APPLICATION NO. 03 DRB-00643	PROJECT NO. 1002602
PROJECT NAME EAGLE ROCK ESTATES, UNIT 2	
EPC APPLICATION NO.	
APPLICANT / AGENT MARK GOODWIN	PHONE NO. 828-2200
ZONE ATLAS PAGE C-18	
(SDP for SUB), (SDP for BP), (FINAL PLATS), (MASTER DEV PLAN), (IR), (AA)	
ONE STOP COMMENT FORM LOG

DEVELOPMENT REVIEW BOARD--SPEED MEMO

DRB CASE NO/PROJECT NO: 1002602

- 2. Project # 1002602**
03DRB-00642 Major-Vacation of Public Easements
03DRB-00643 Minor-Prelim&Final Plat Approval

EAGLE ROCK ESTATES - UNIT II
 POND RECLAMATION
 GRADING AND DRAINAGE PLAN

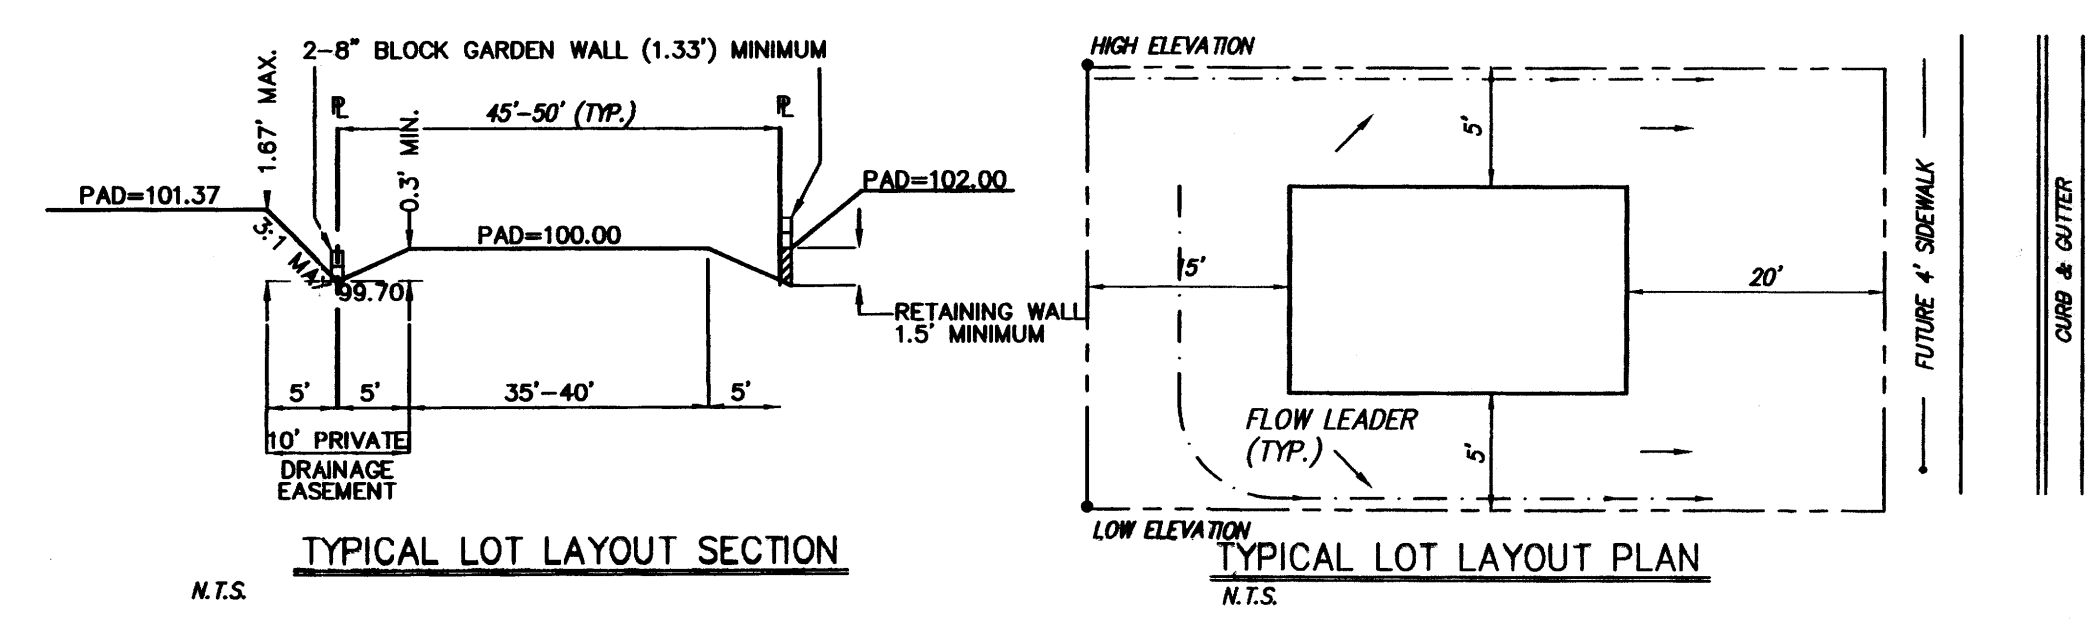
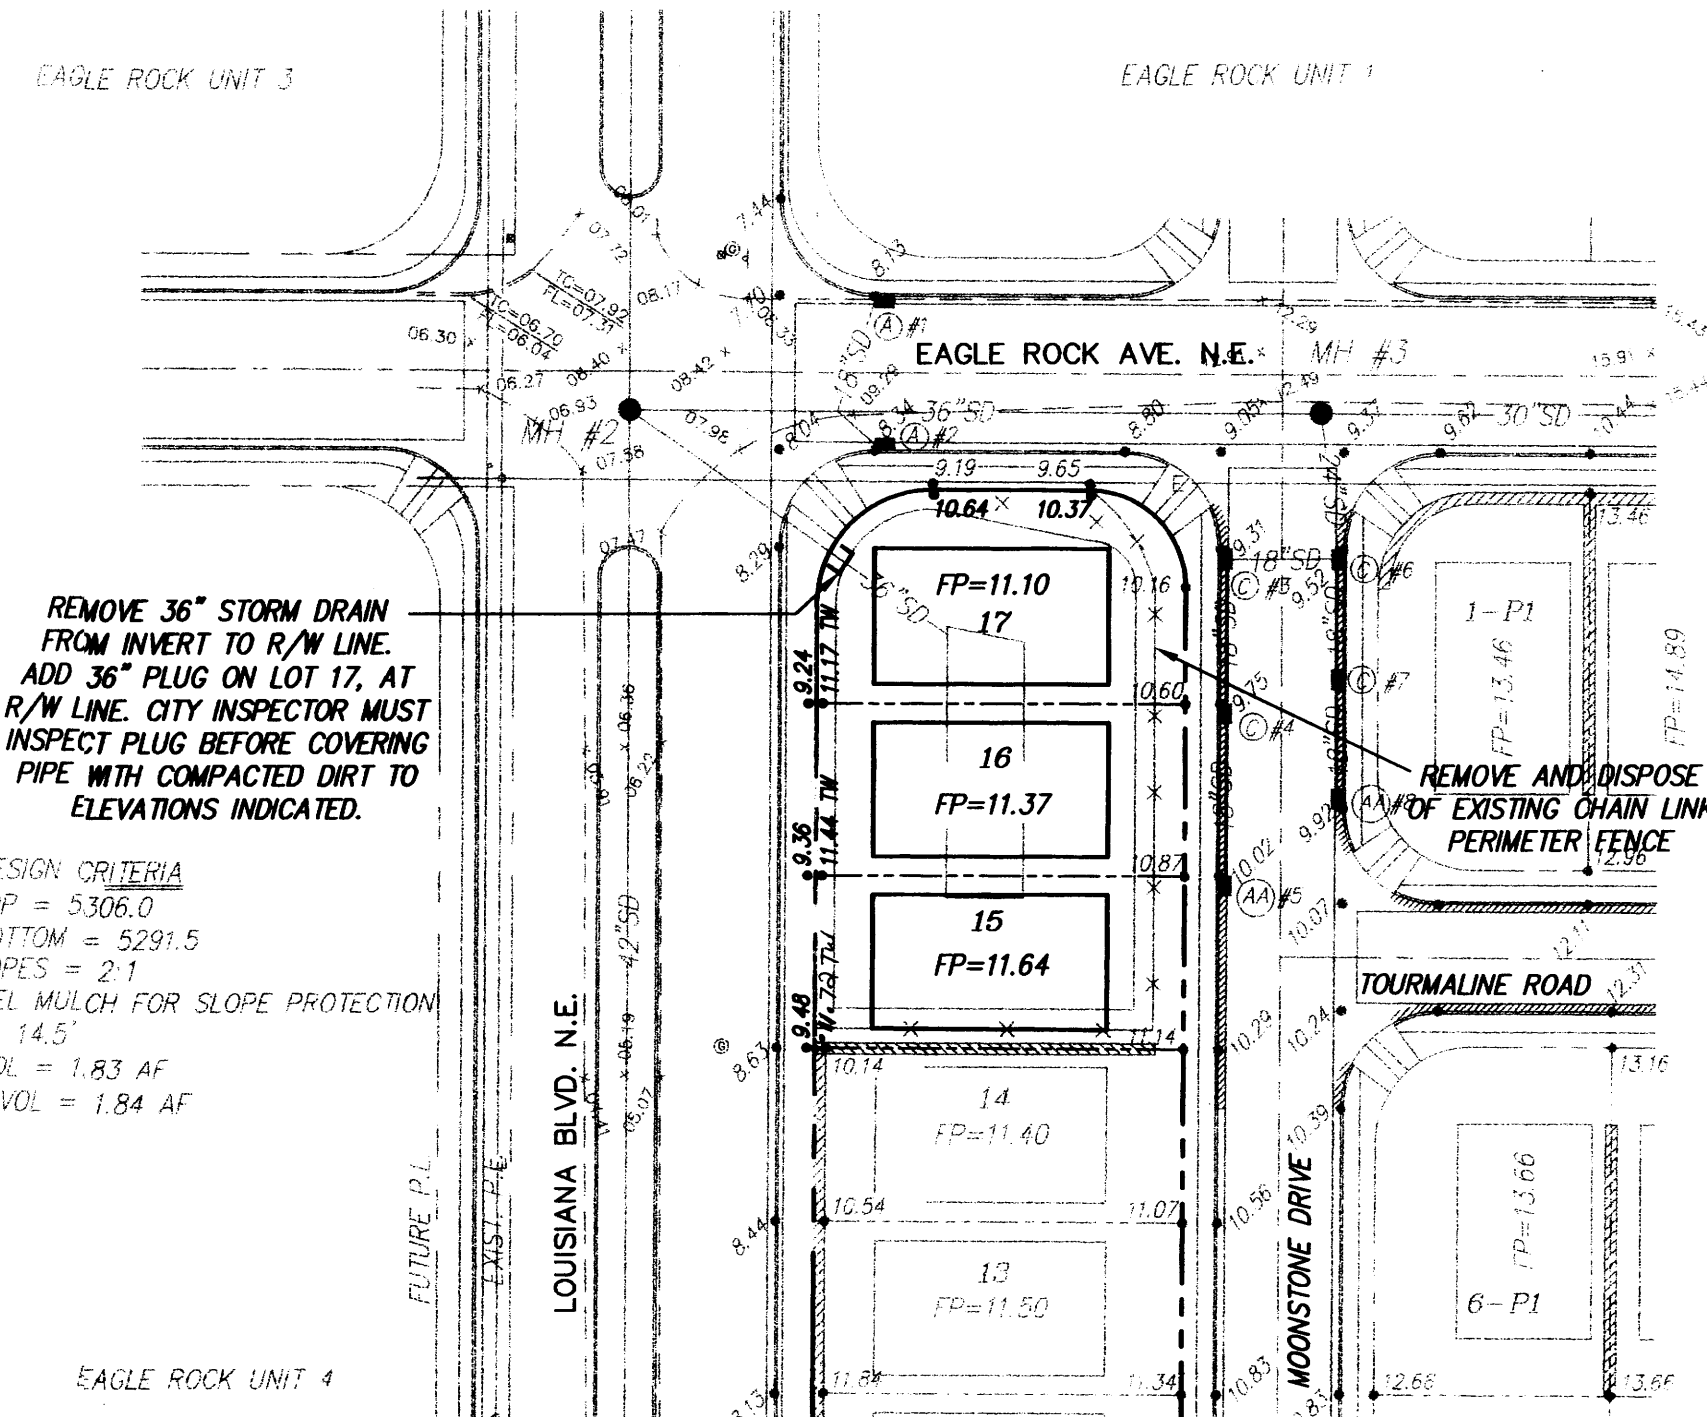
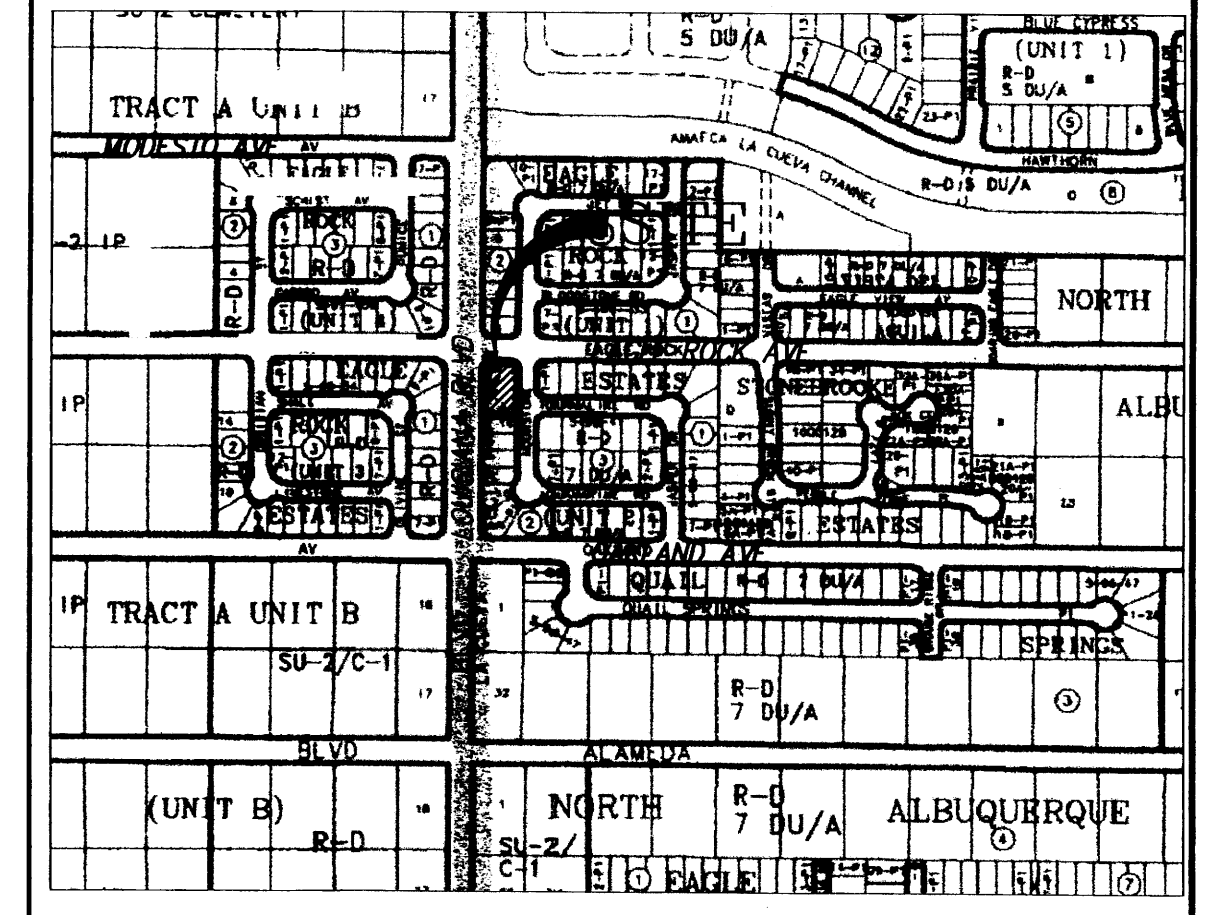
The Hydrology Section has no objection to the vacation request.
 An approved drainage plan dated 4-22-03 is on file for Preliminary Plat approval.
 Engineer's Certification of the grading plan is required for Final Plat sign-off.

No objection to vacation request. Approved grading and drainage plan required prior to Preliminary Plat approval. Engineer certification of grading plan required prior to City Engineer signoff of Final Plat.

With the approval of the grading plan engineer stamp dated 4/22/03 the preliminary plat was approved with final sign off delegated to City Engineer for engineer certification of grading plan and 15-day appeal period and to Parks for Open Space note, park dedication and the DXF file.

1. To subdivide Tract "A", Block 2 into 3 residential lots.
2. Vacate temporary Public Drainage Easement as shown hereon.

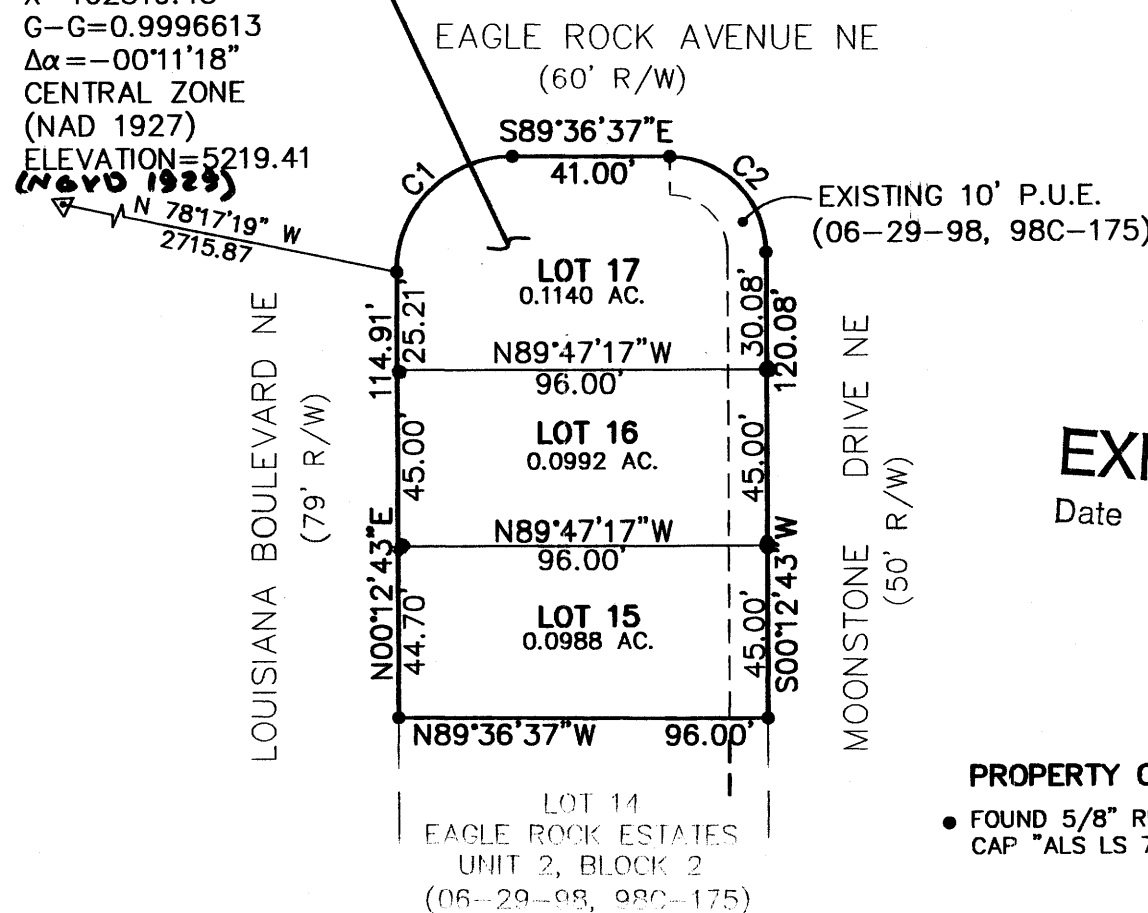
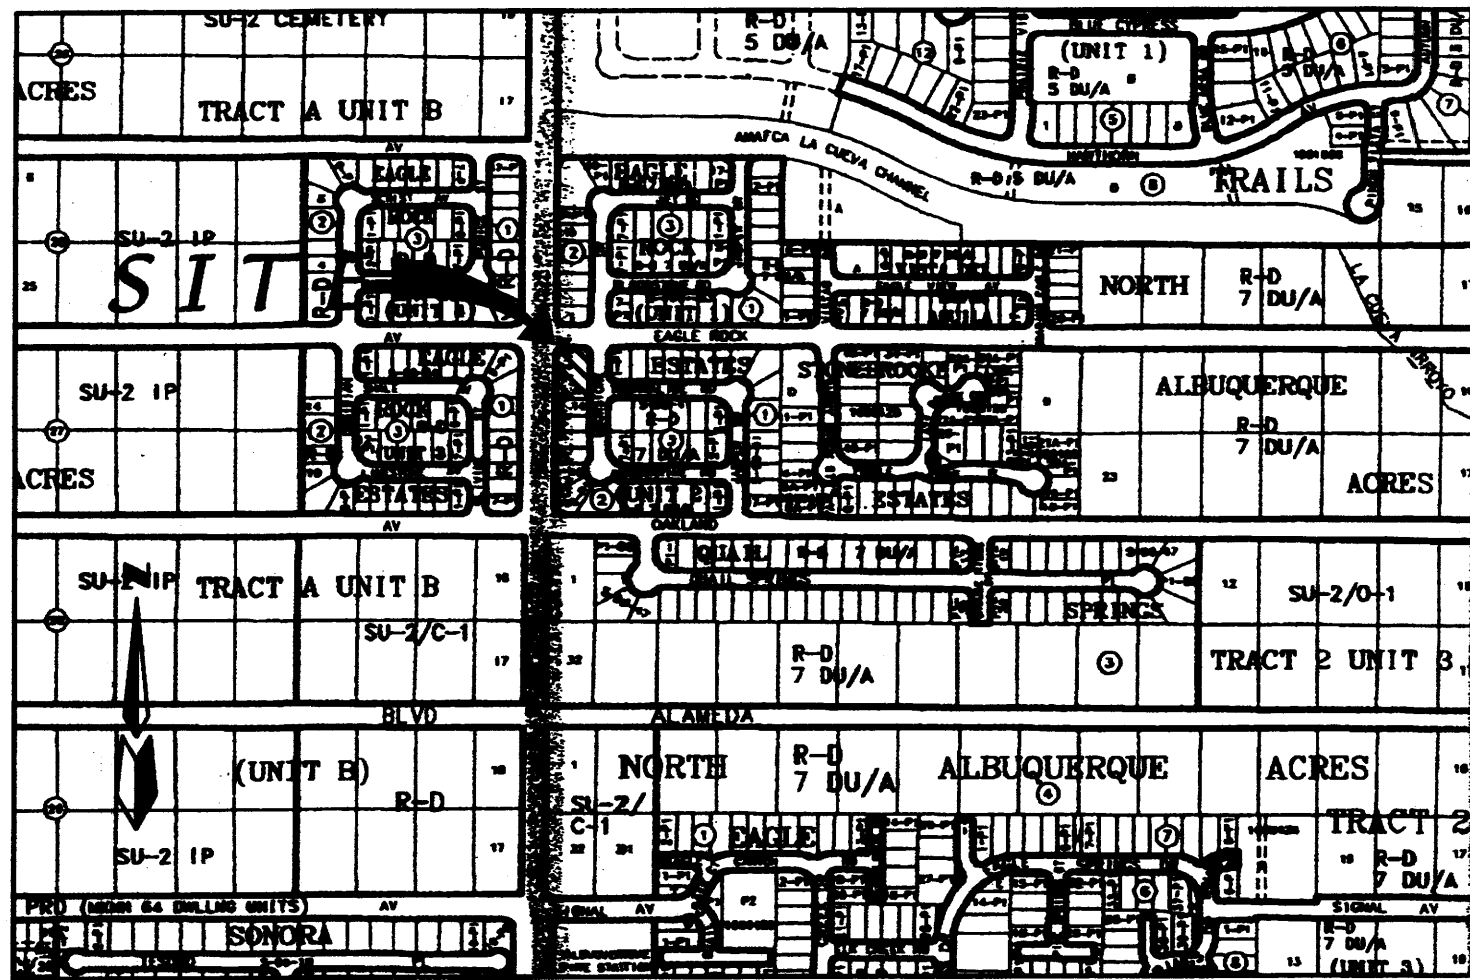
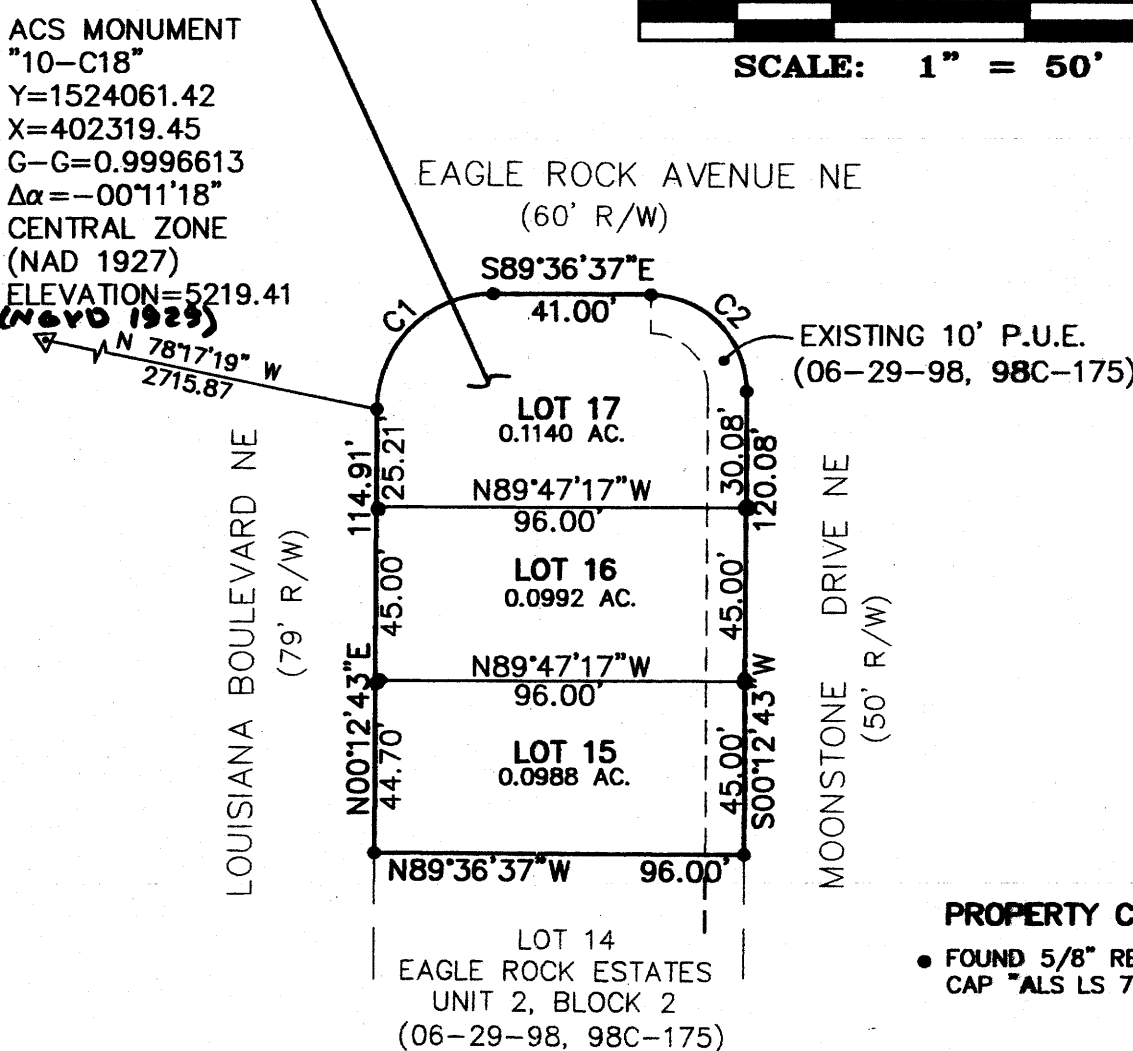
No objection to the vacation request.

Prior to sign-off on the final plat, a fee in-lieu of and equal to the value of the required park land dedication for 3 new residential lots will be required. The fee will be based on an estimate of land value to be provided by the City Real Property office. Alternatively, the applicant may submit current appraisal information mutually acceptable to the applicant and the City.

The R-D zone requires 2,400 square feet of open space for each dwelling unit. With submittal of the Preliminary Plat/Site Development Plan, provide an Open Space Calculation Table showing the lot number, lot size, building & driveway area, provided open space, remaining open space requirement (this table can be separate from the plat itself). Provide a dimensioned Typical Lot Plan, which shows a typical lot with the building footprint and driveway (this should be on the Site Development Plan rather than the plat). Include one of the following notes on the Preliminary and Final Plats indicating how the total remaining open space requirement will be met:

Applicant is required to submit a digital dxf file and one hard copy of the plat for AGIS approval before Planning will sign the plat. AGIS will provide applicant with a signed approval sheet. Bring this sheet and the mylar to the Development Services front counter for Planning's signature.
